From: [Brenda Larsen](#)
To: [Jeff Watson](#)
Subject: RE: BL-10-00031 Lohnes
Date: Friday, July 30, 2010 4:01:48 PM

After conducting a review of the above named project, I have the following comments:

BOUNDARY LINE ADJUSTMENT

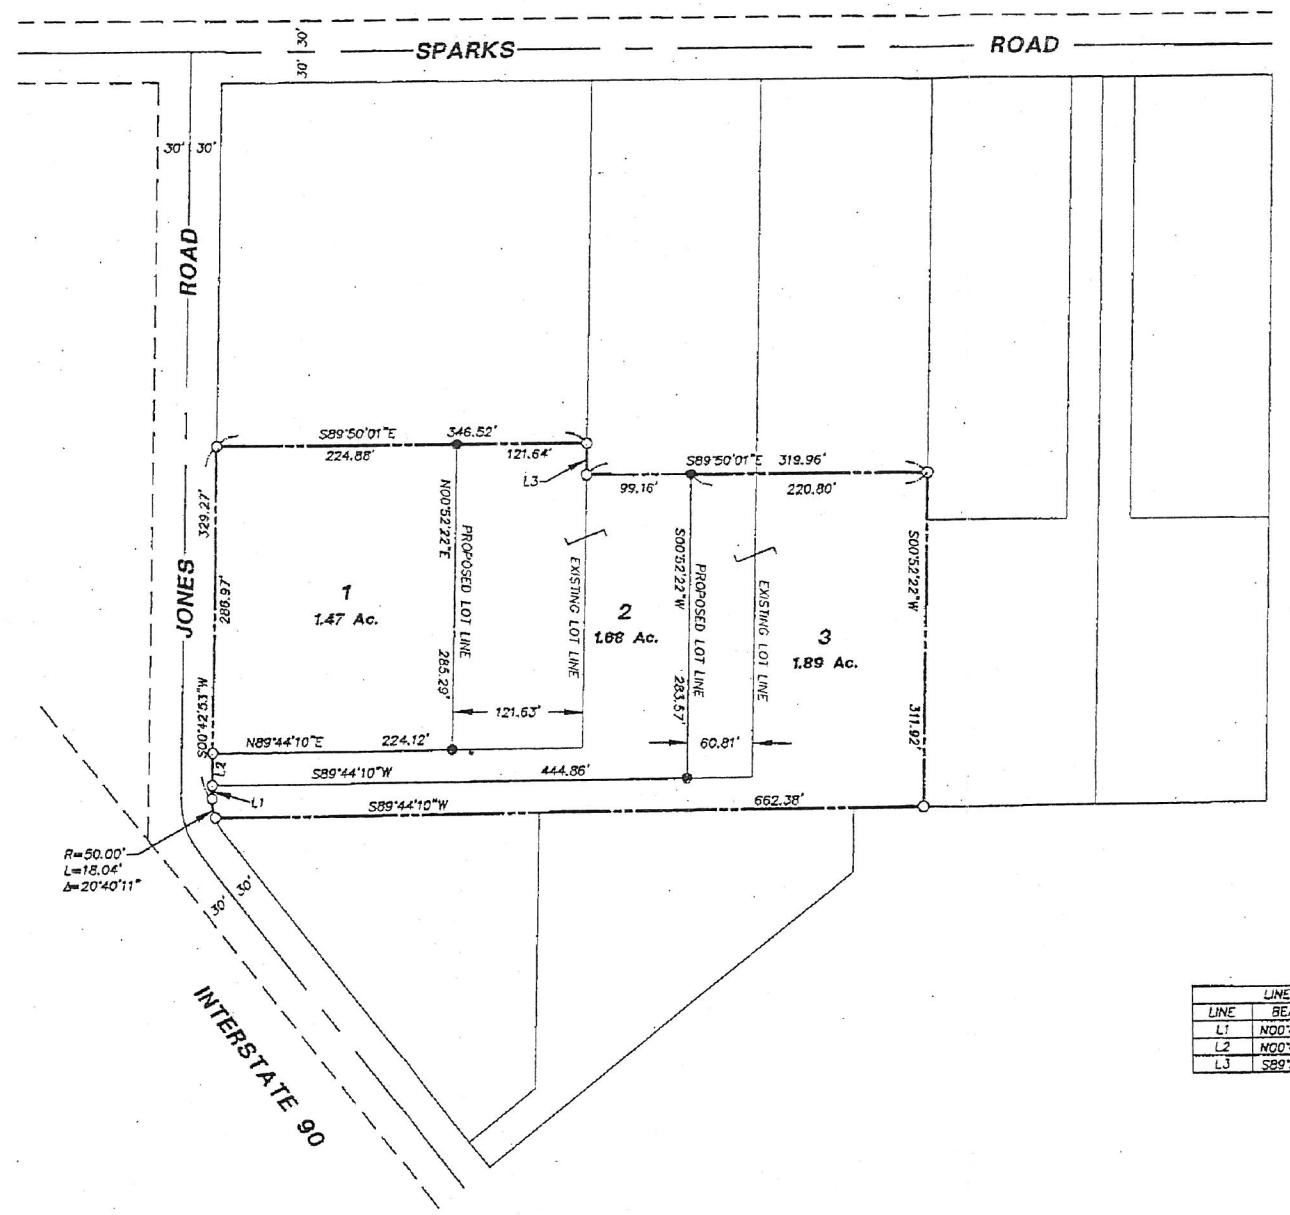
- All future development must comply with the International Fire Code.
- Ensure that boundary line adjustments do not infringe upon existing structures, to include propane tanks, etc.
